North Central Area Committee Meeting

SHD0019/22

**North West Corner of Omni Park Shopping Centre,
Santry Hall Industrial Estate, Swords Road, Santry,
Dublin 9.**

Presentation conducted by Rebecca Greene, Executive Planner, on planning application SHD0019/22 (ABP-314458-22) for the construction of 457 Apartments, Crèche and associated works.

02 NORTH ELEVATION - UNDERCROFT
P4001 SCALE 1:200 @A1

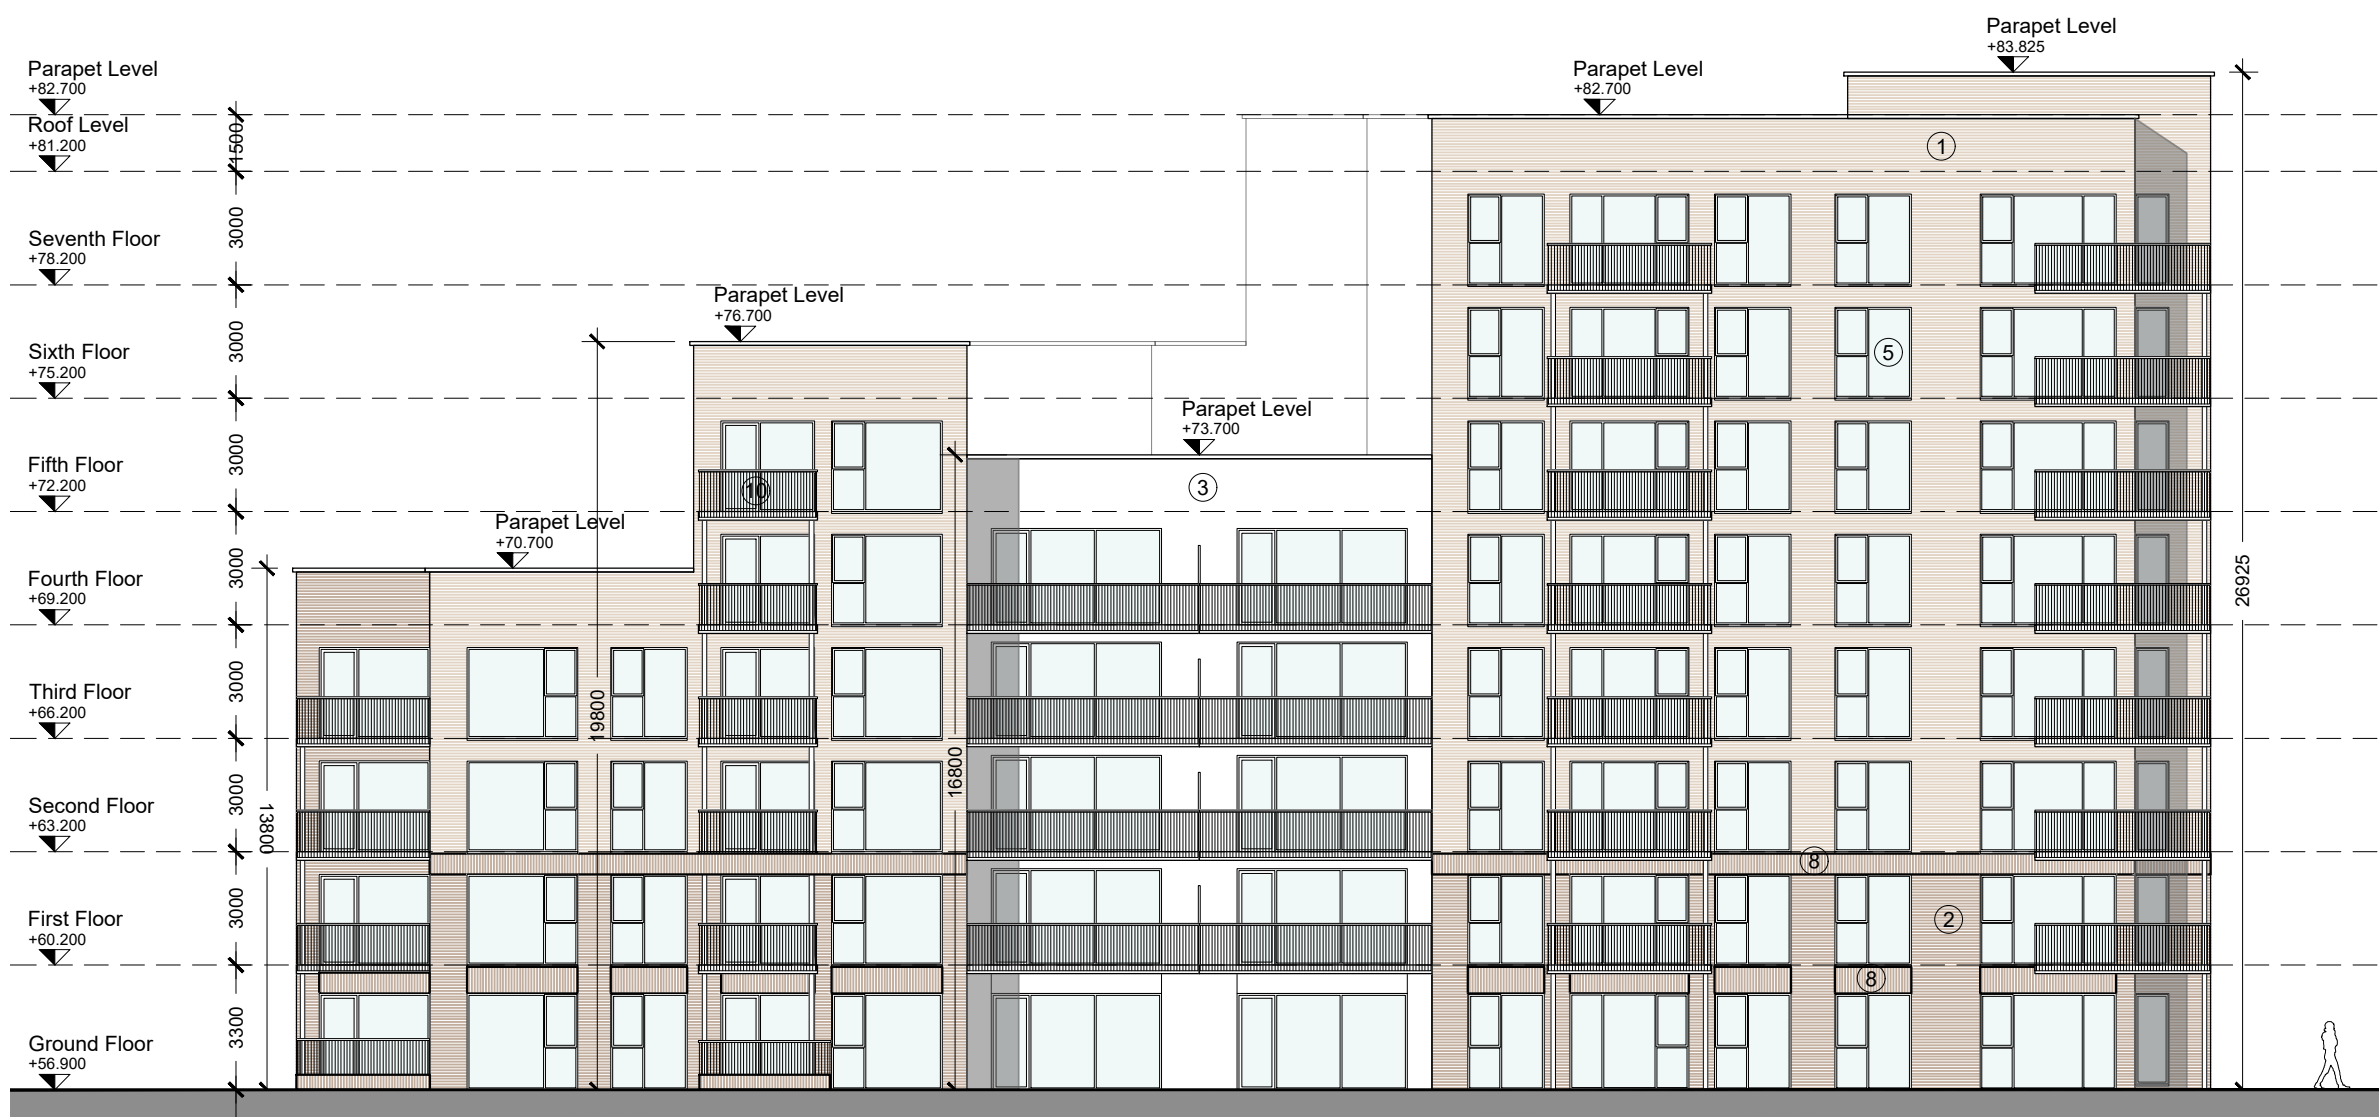
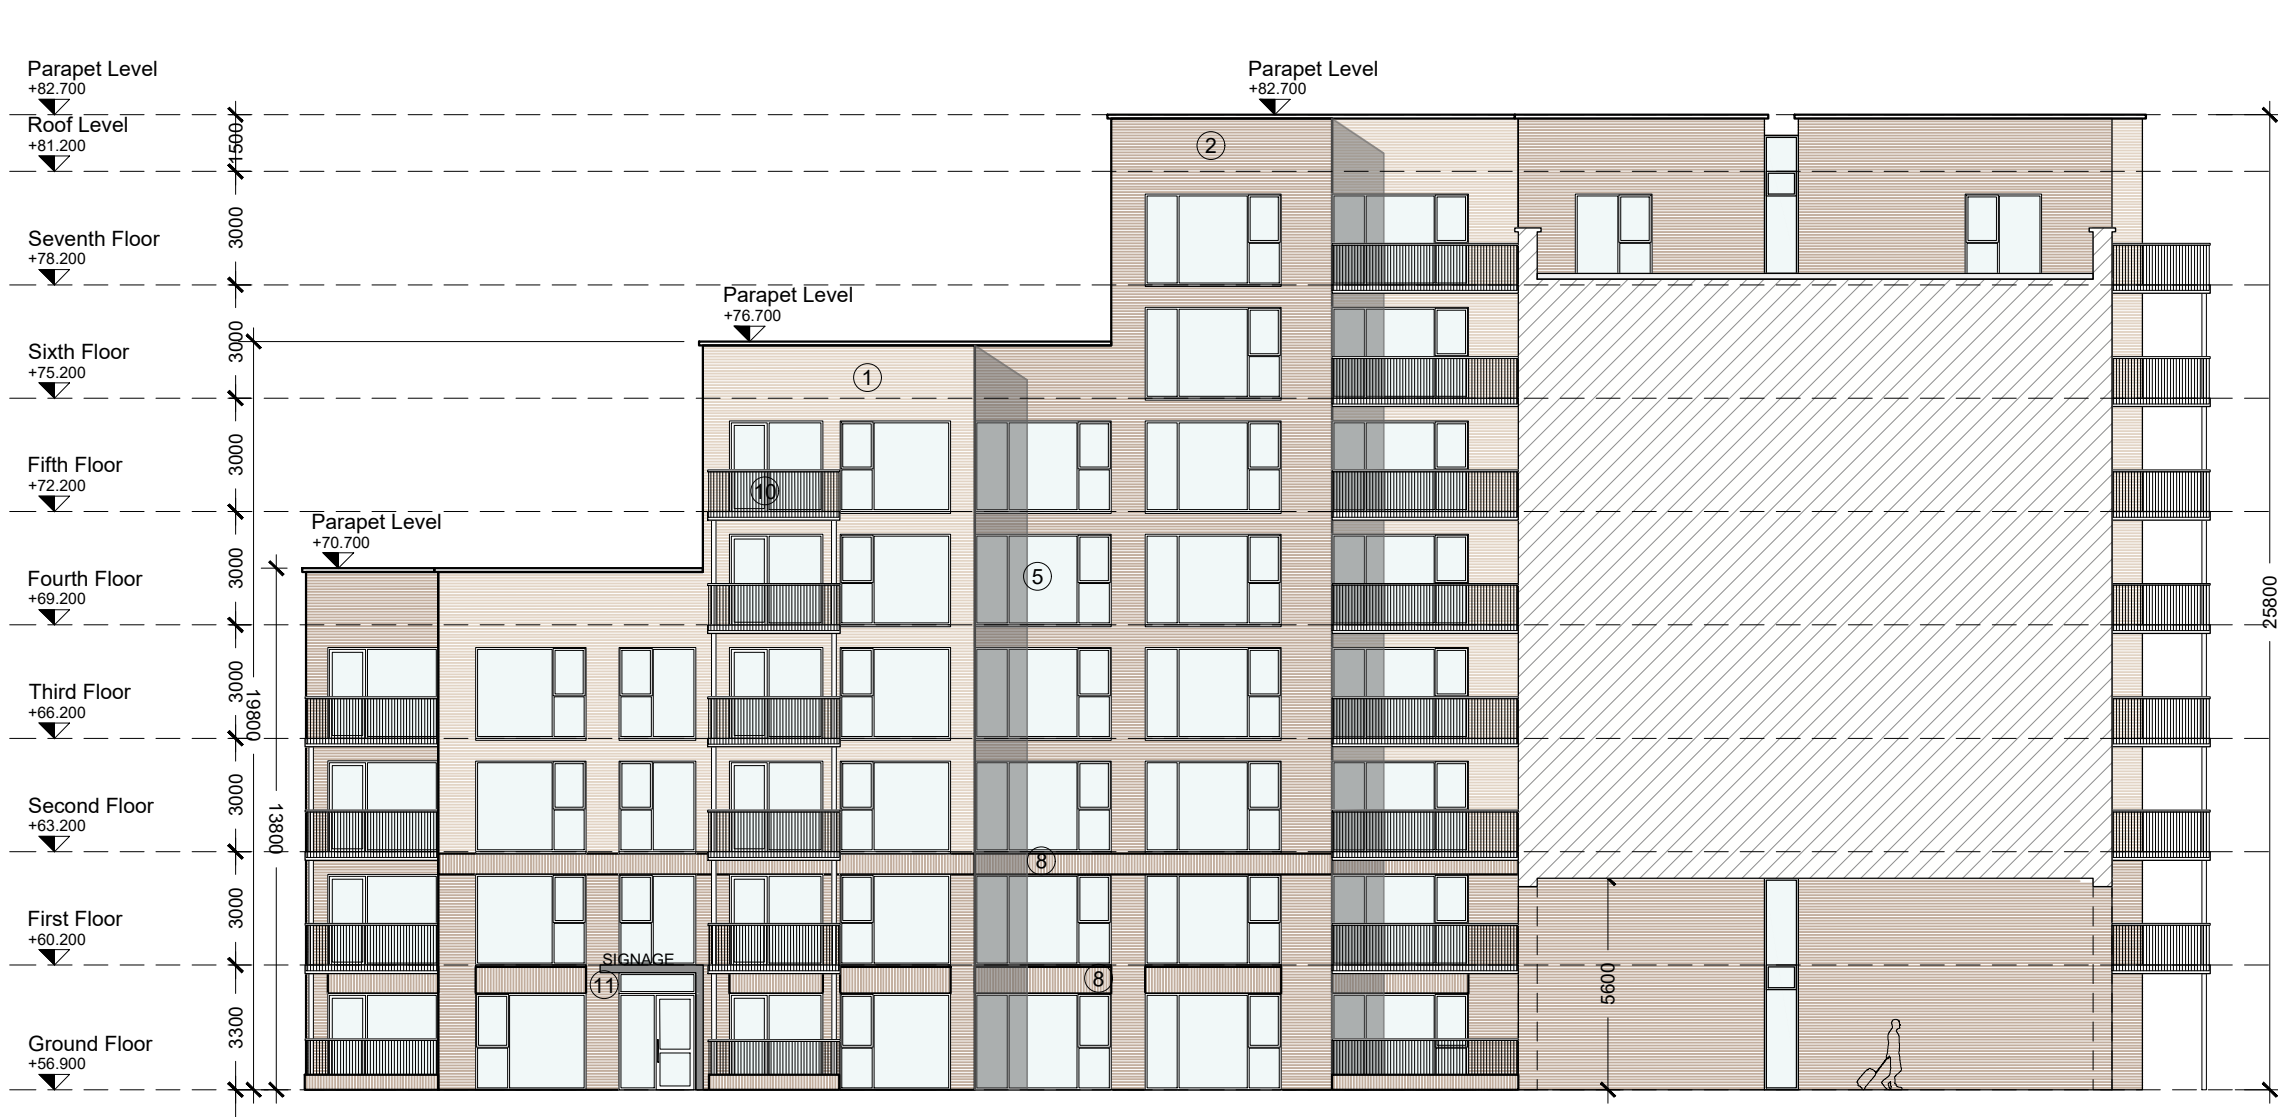
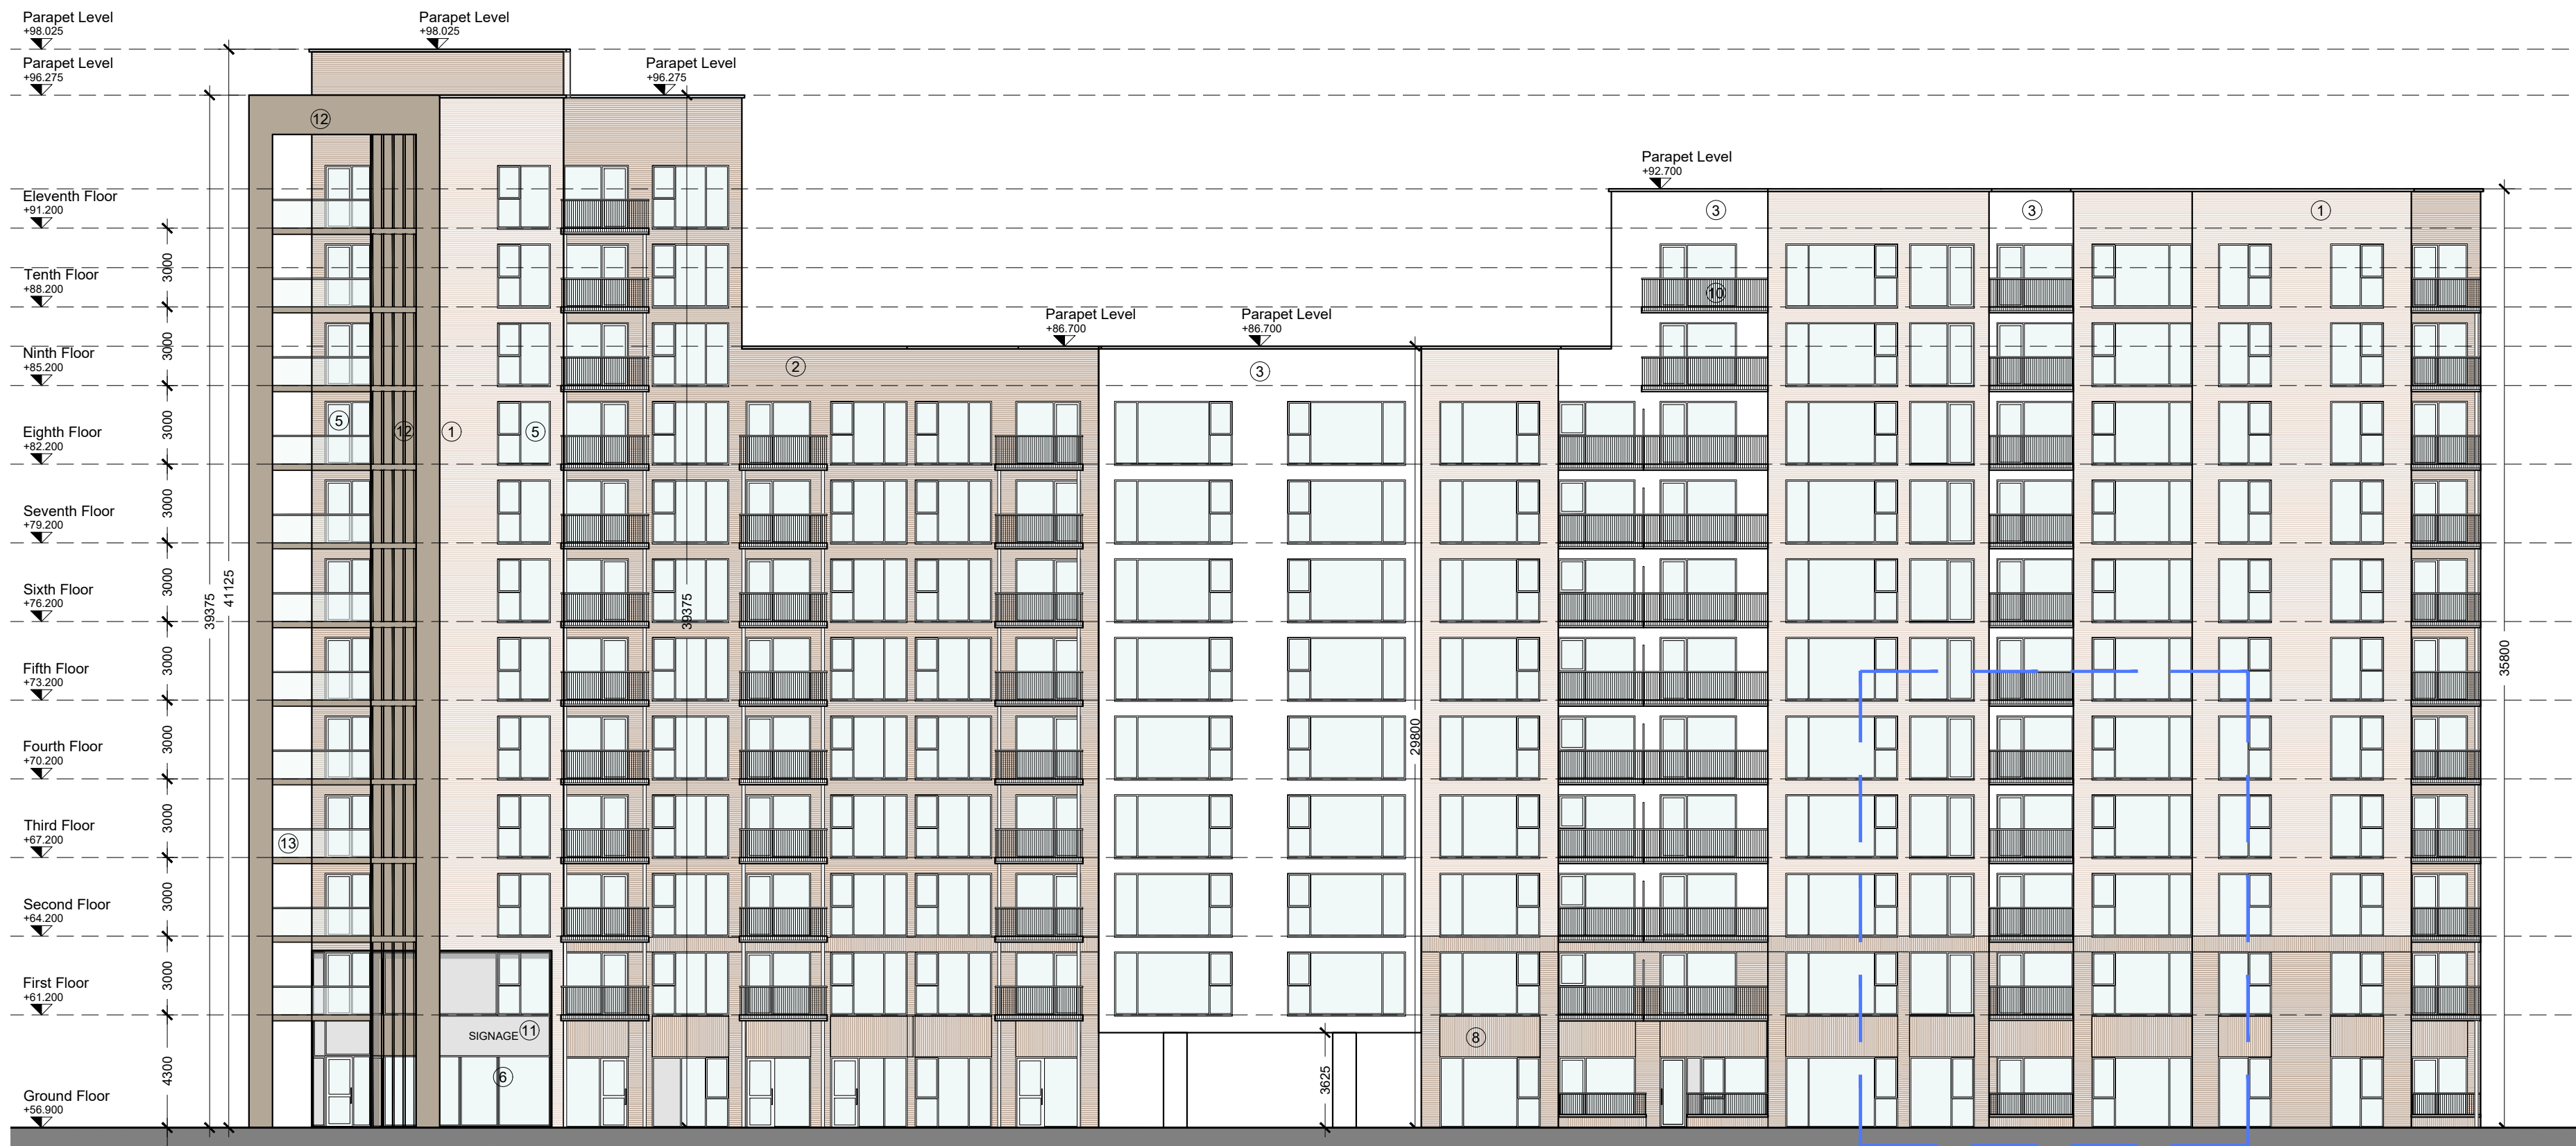
Clarity was also sought in relation to the actual heights in metres of the various blocks in the development and the distances in metres from the prospective development site to Shanliss Ave and concern was expressed of the visual impact on the skyline in a settled two storey residential area and reference made that this application should be declined on the basis of a material contravention
